Re: Objection to planning application AW/66/22/HH

Thank you for returning my call last week to discuss our objection to the above application. As requested we have set out our objections below and you will recall that we live exactly opposite 36 Kingsway and can see the existing garage from our property

Proposed West Elevation

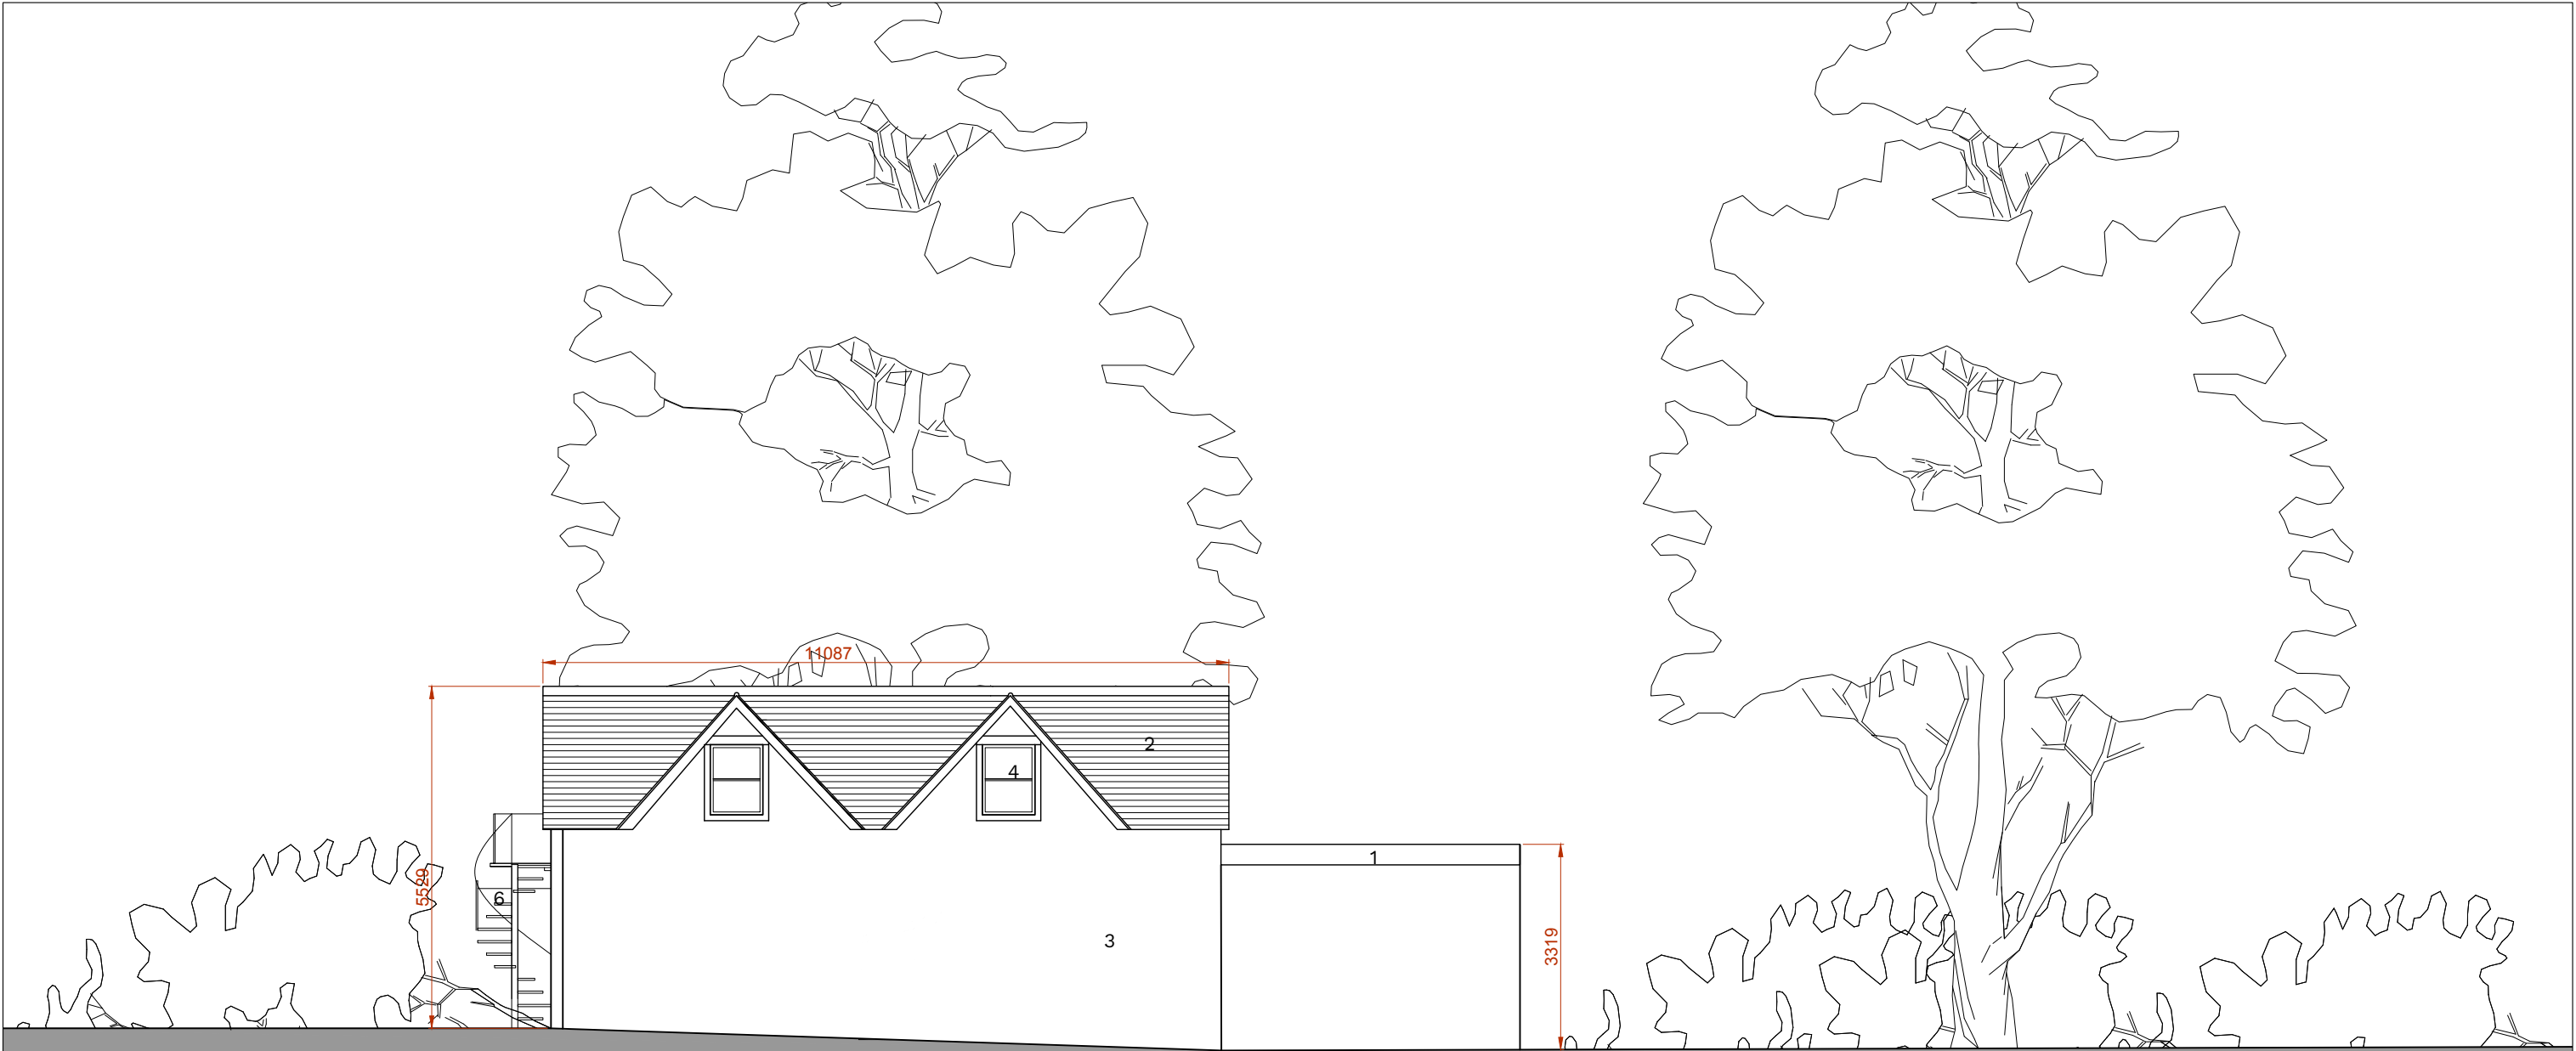
3. The proposal is for a large and high building which is built along a boundary wall which will result in it significantly overlooking 34 Kingsway. The level of intrusion reduces and removes the privacy of a neighbour's property and perhaps the sightlines intrude even into the neighbour's home. From a distance the same influence may apply to more than one neighbour

4. When in use during the winter or darker periods the structure will need internal lighting which will create pollution by way of light. If an exterior light is added above the planned spiral

staircase this again will create pollution by way of light in an area of very limited external lighting

Drawing Details
Proposed First Floor Plan
PLANNING ISSUE

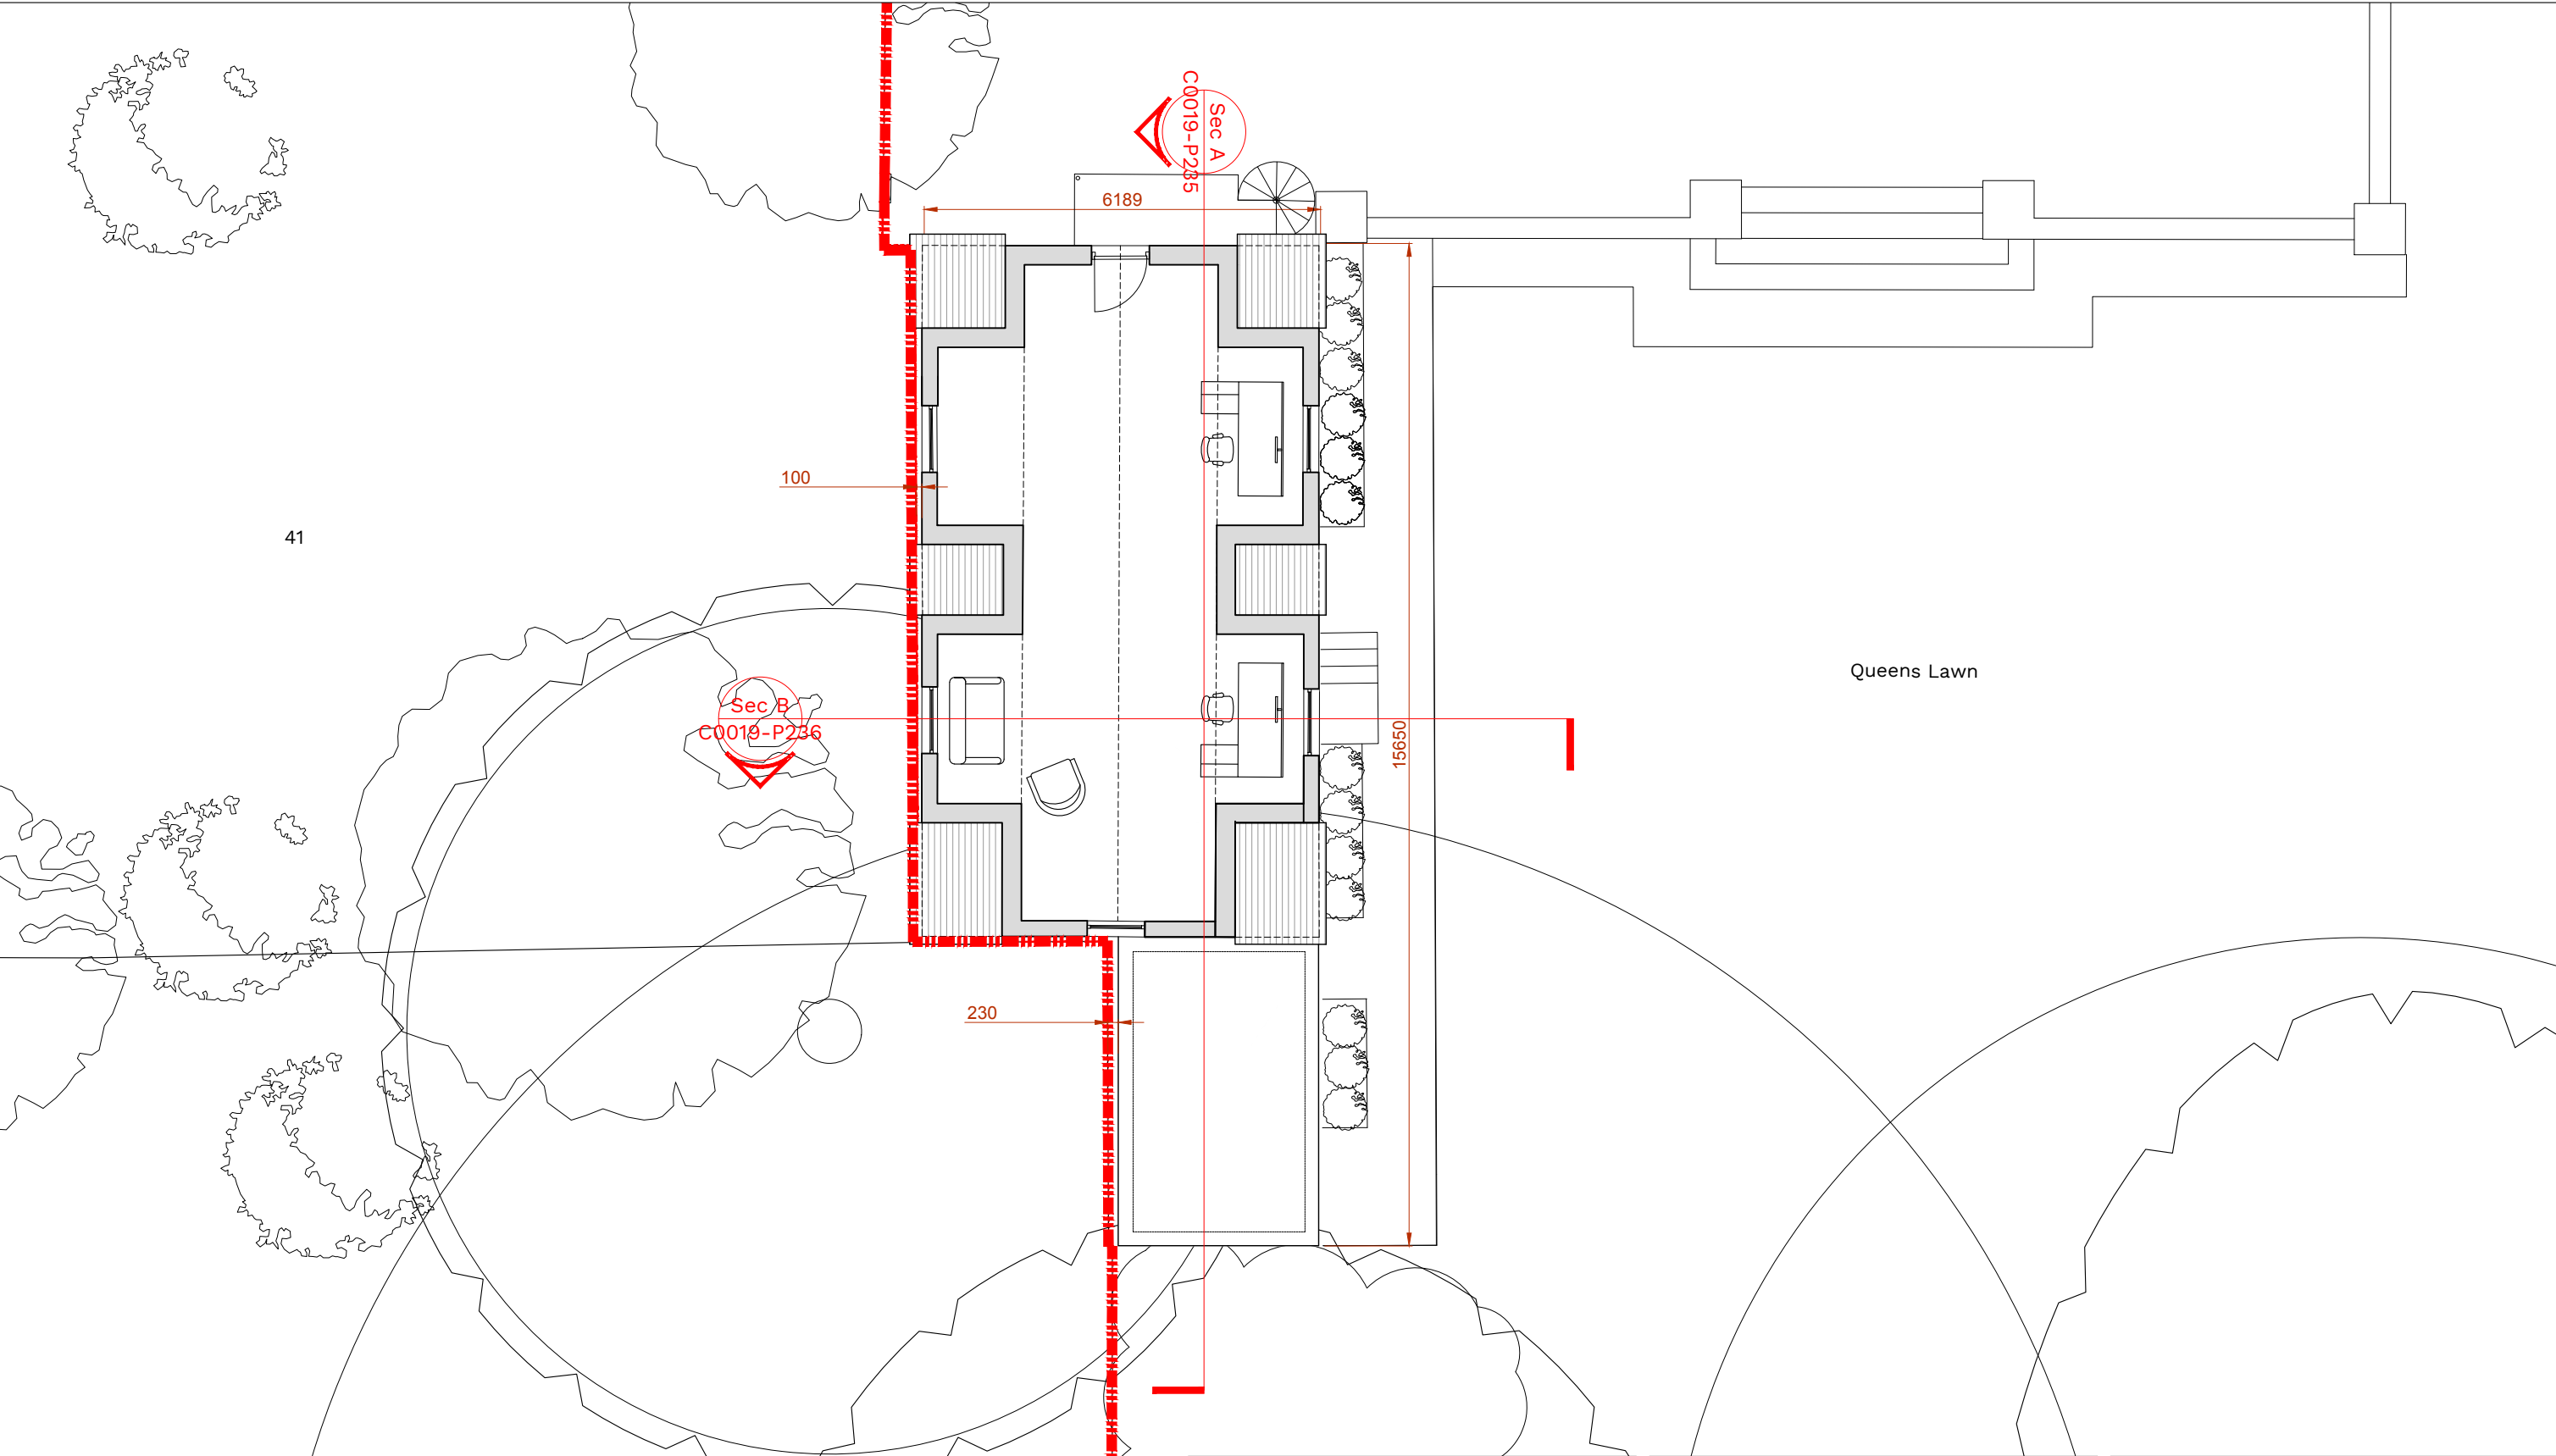
5. Having spoken directly to the applicant he has stated that the extended area is solely for his own use as a home office. However the plan shows two desks and sitting out areas. However the size of the area could accommodate up to four large desks plus office equipment. This raises a question as to whether or not the developed area would indeed be solely for the use of the applicant?
6. The plans do not show arrangements for guttering and drainage however it seems clear that maintenance could only be carried out, in part, from within the neighbour's property
